**Consultation Response from KC,
Lead Local Flood Authority**

2025/93464 Spinksmire Mill, Huddersfield Road, Meltham, Holmfirth, HD9 4AN

Demolition of existing building and erection of industrial building

Date Responded: 15/04/2026

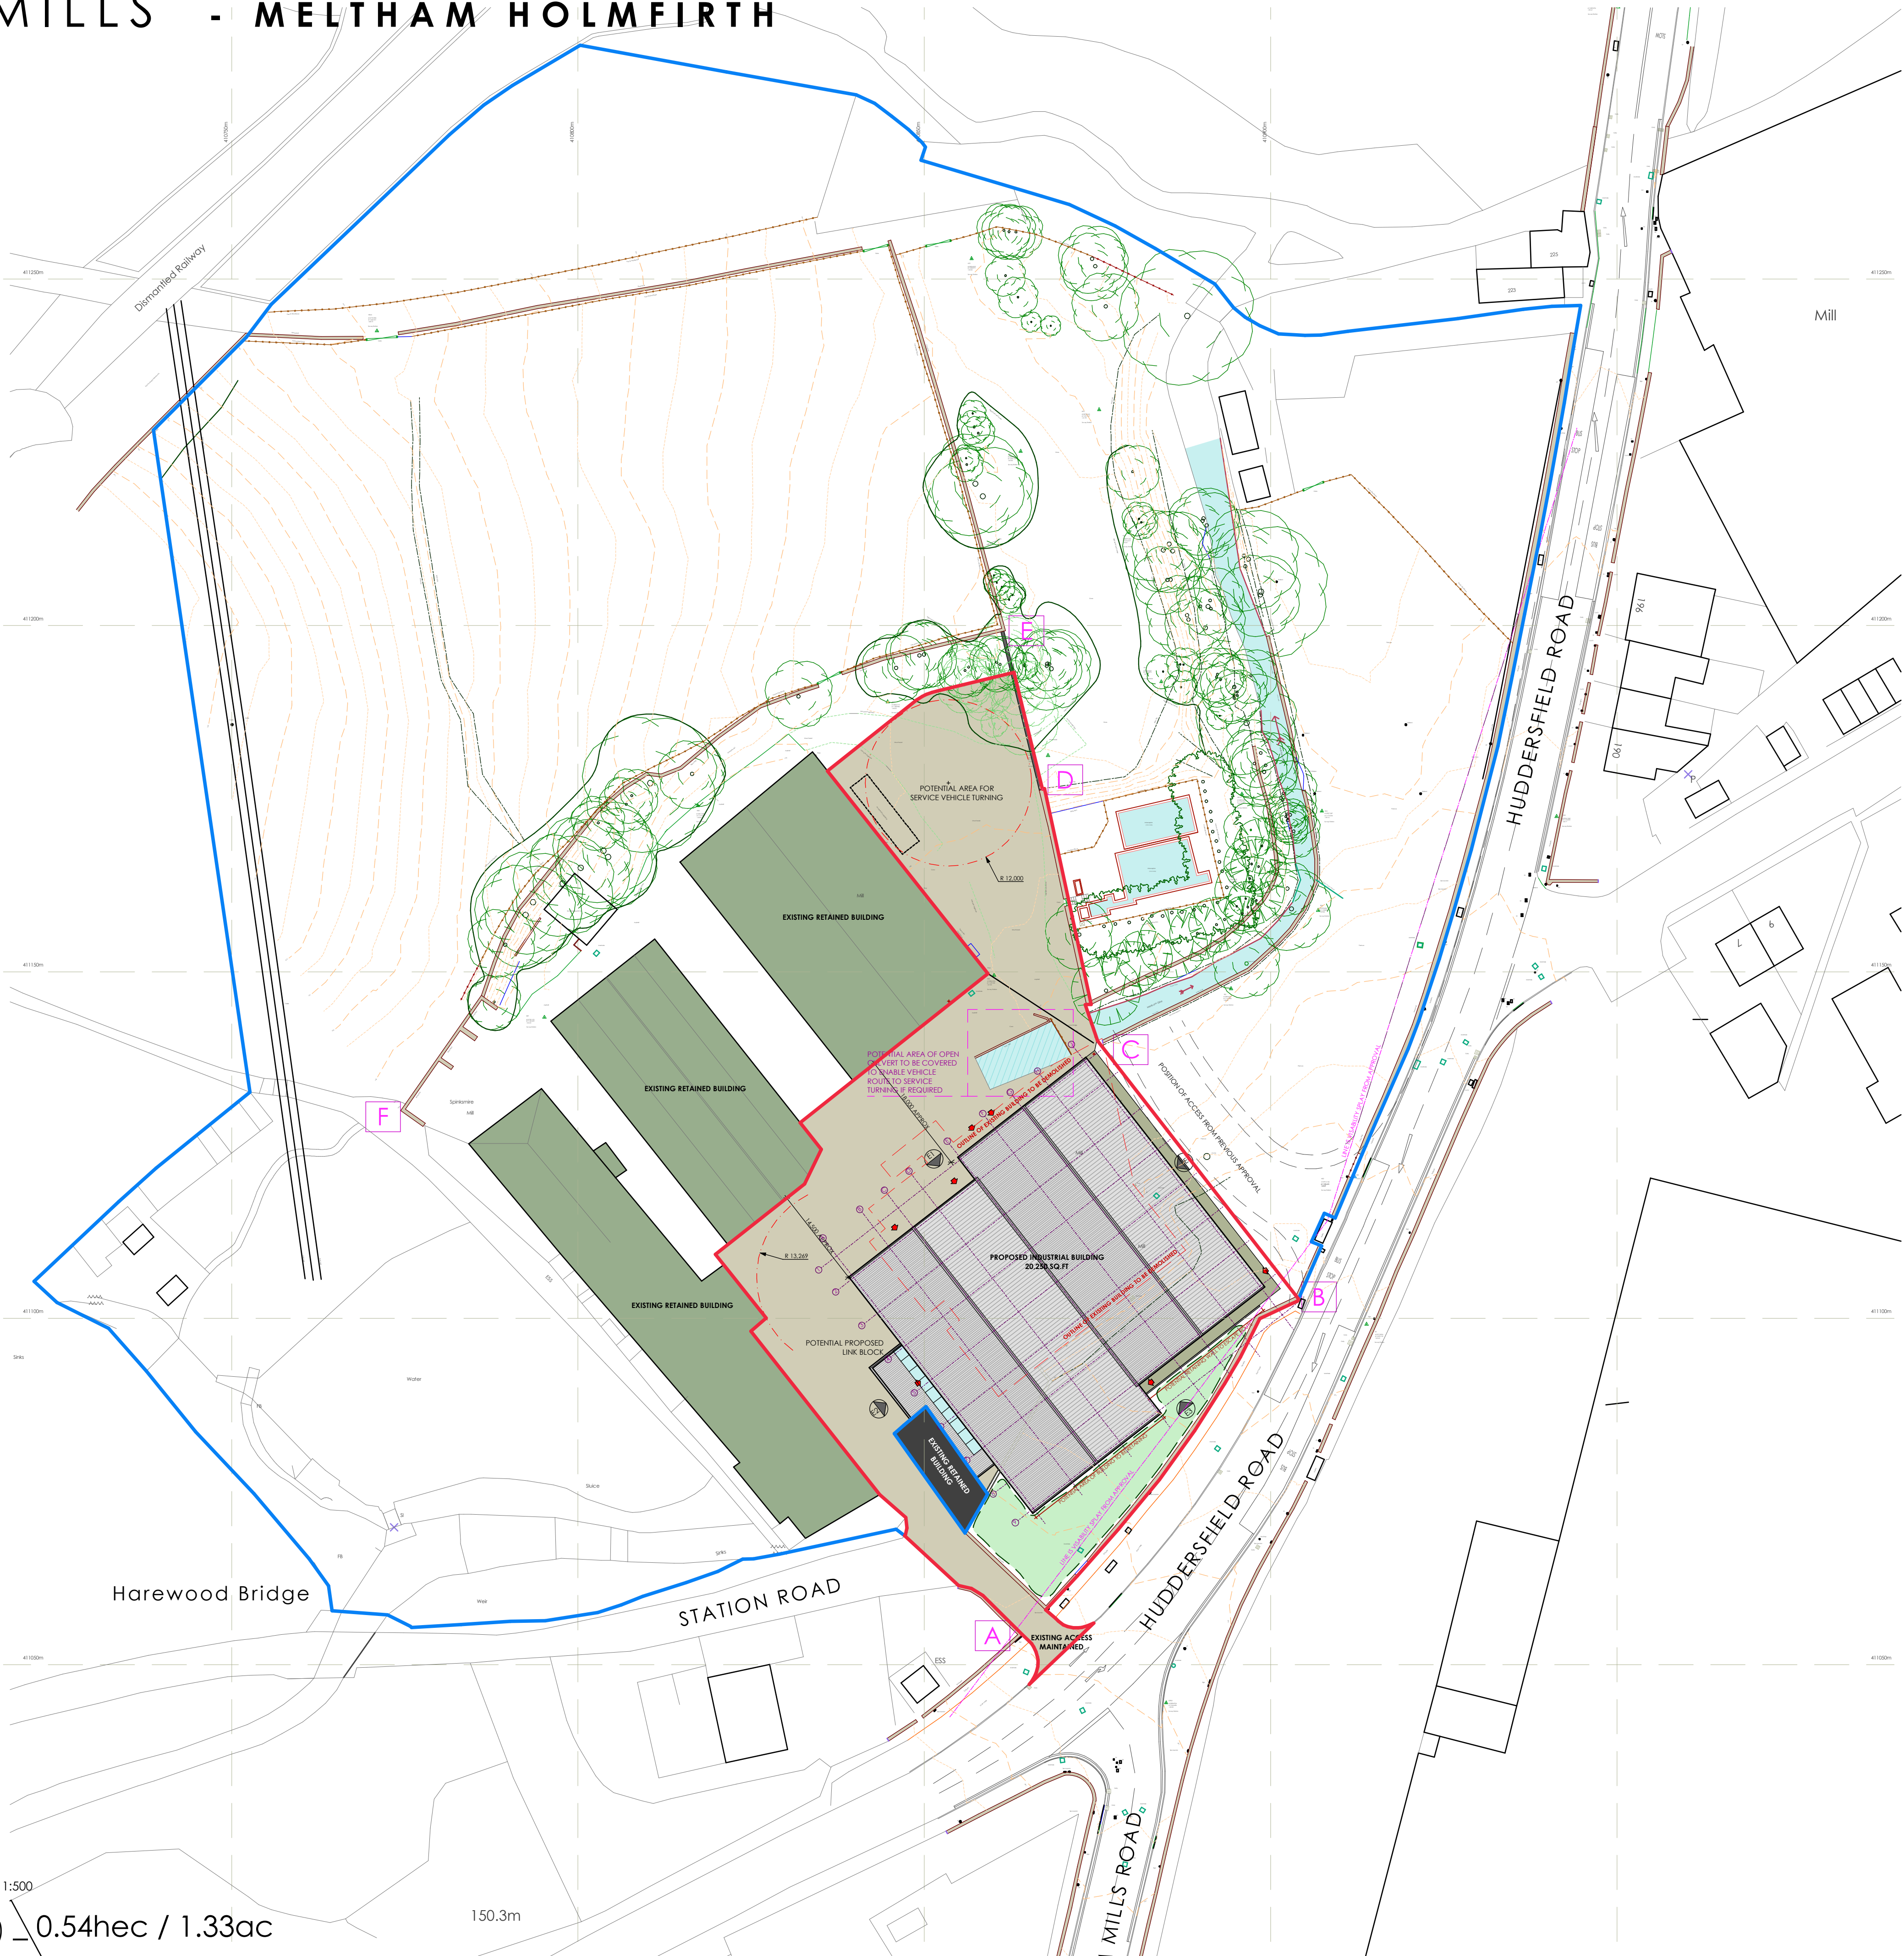
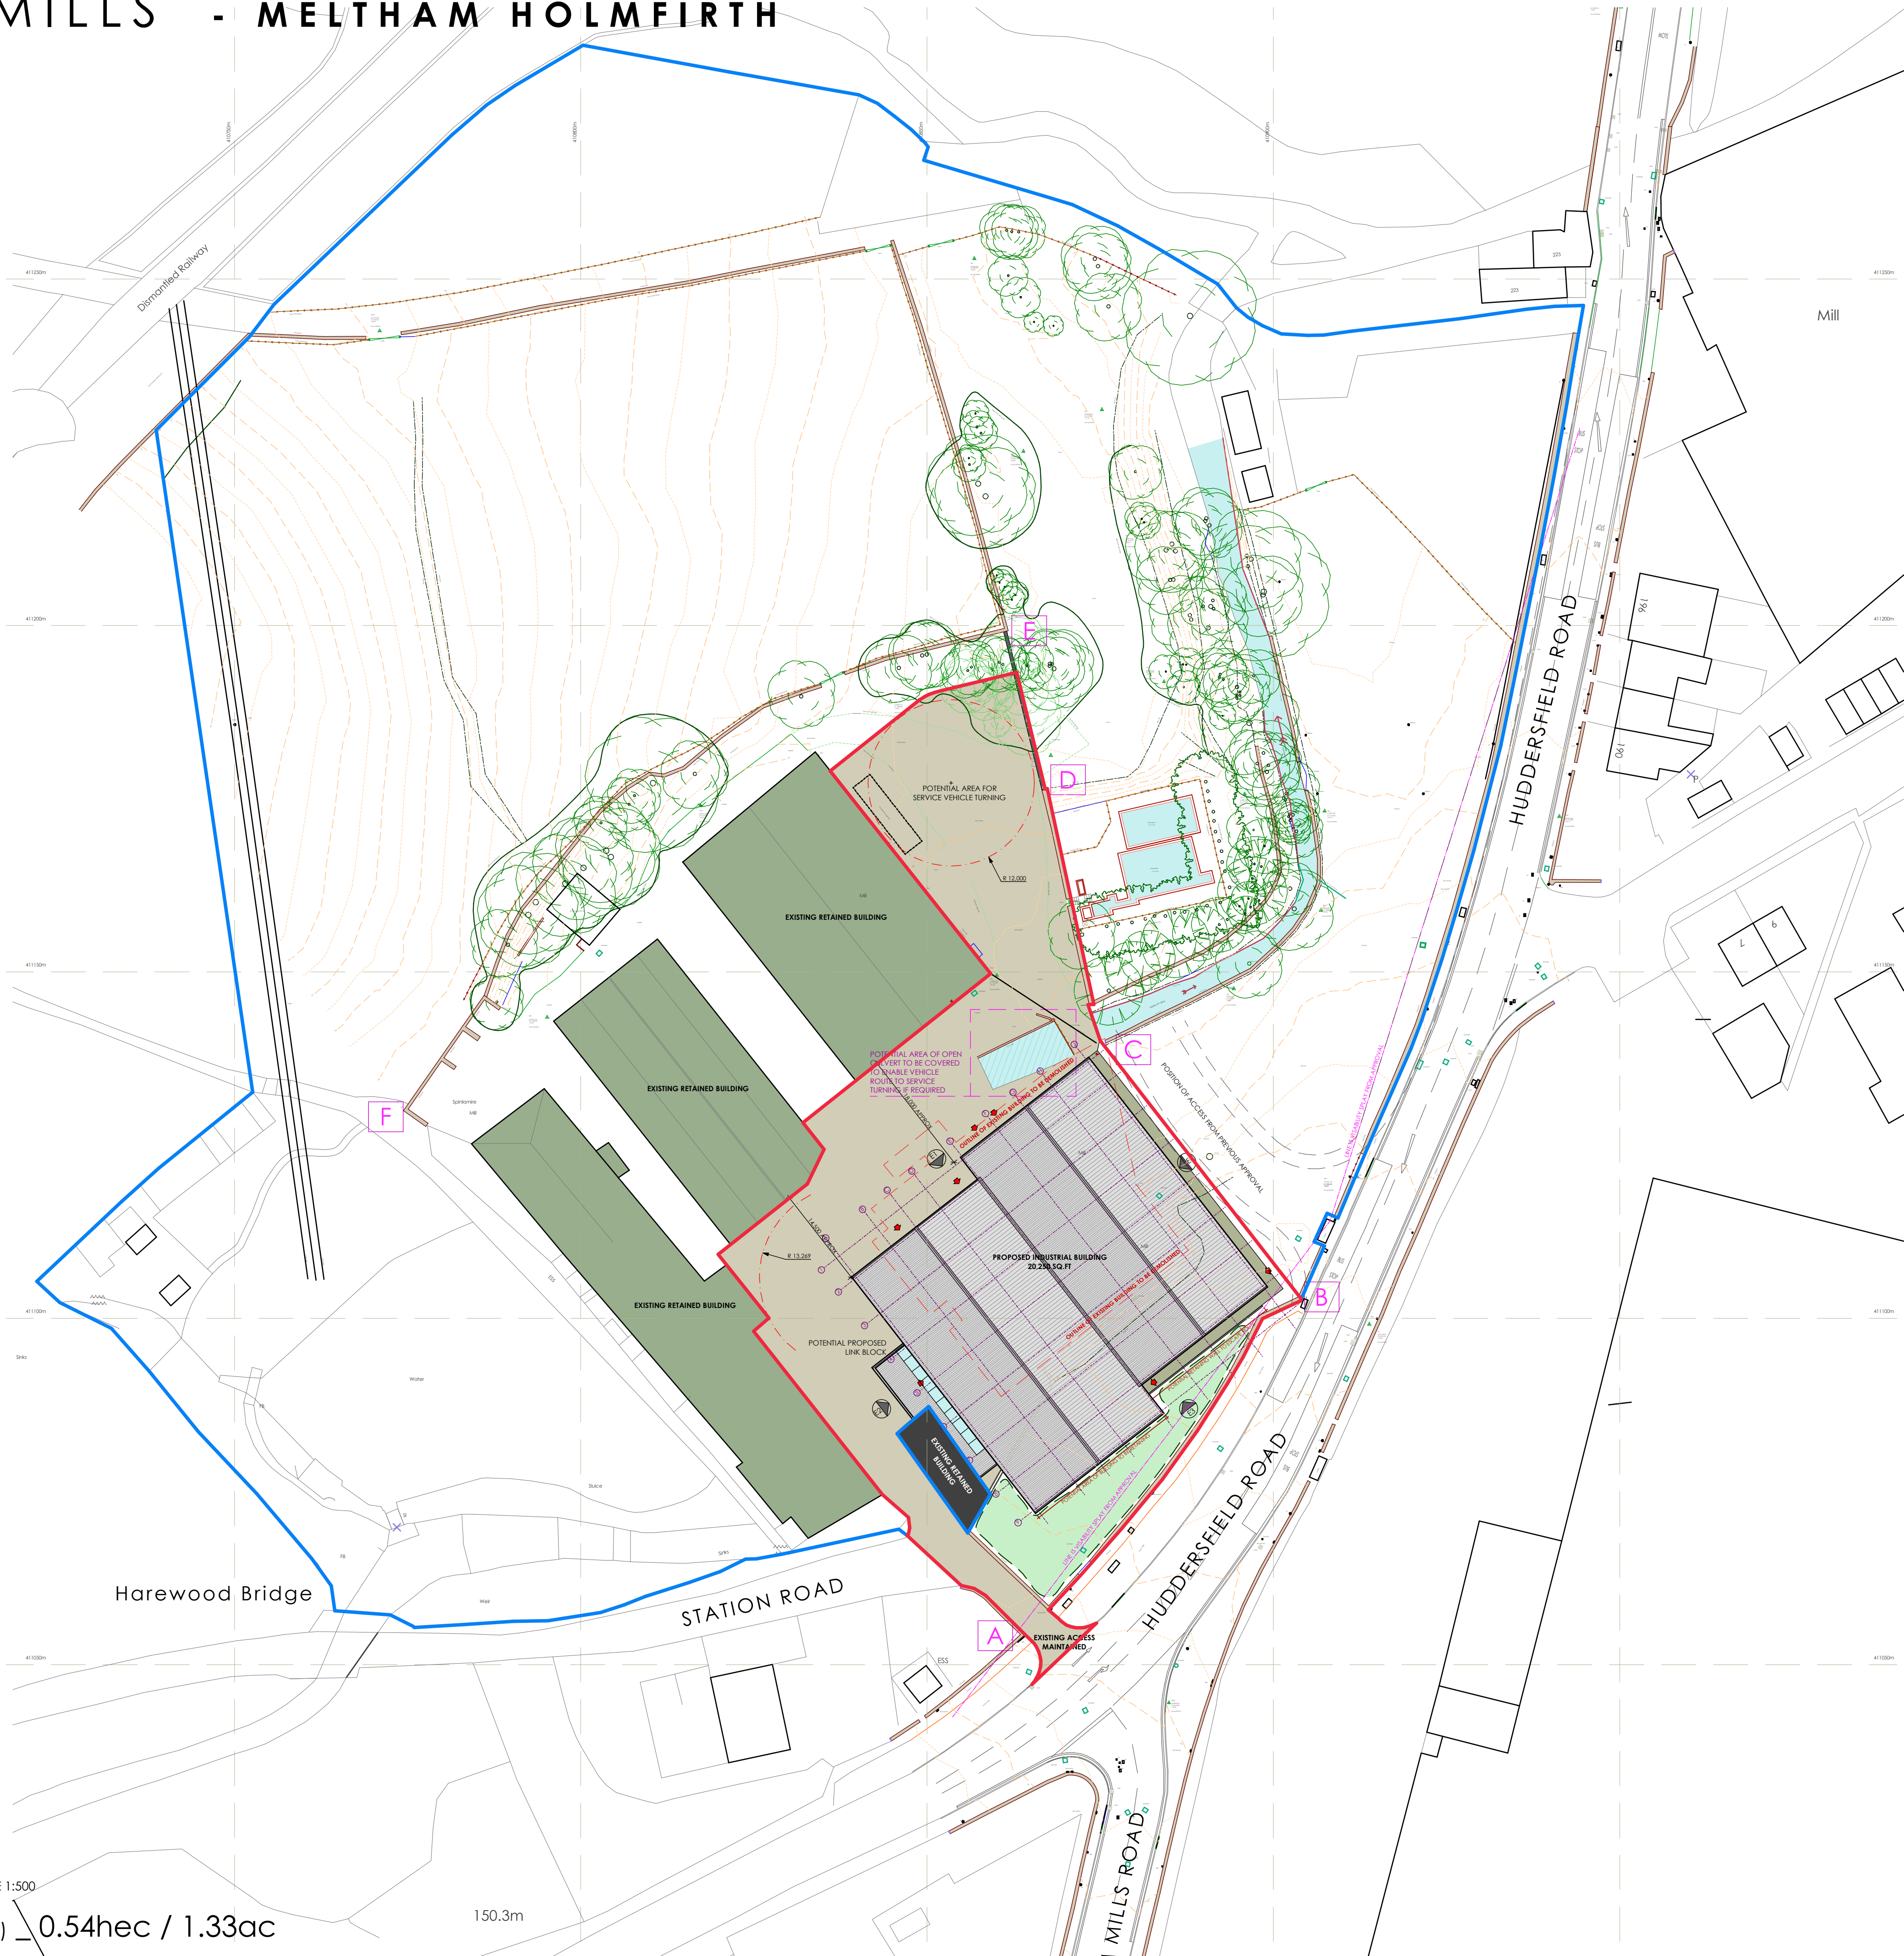
The LLFA confirms that the FRA produced by Andrew Moseley Associates is generally accepted, however it is noted that no drainage strategy has been submitted. In particular, the LLFA note that the proposed building is partly located on an unpaved area (i.e. rough grassland) to the south adjacent to Huddersfield Road which would increase the drained area by approx. 700m². This area would generate approx. 10l/s additional surface water run-off from the site (using the Modified Rational Method).

The FRA does not address the increase in surface water run-off or give the developer's proposals to avoid the associated increase in flood risk. The LLFA would also expect to be provided with details of how the new building, and any associated additional hardstanding, will dispose of surface water run-off.

Kirklees Flood Management and Drainage as Lead Local Flood Authority, OBJECTS to this planning application and requires further information as noted above.
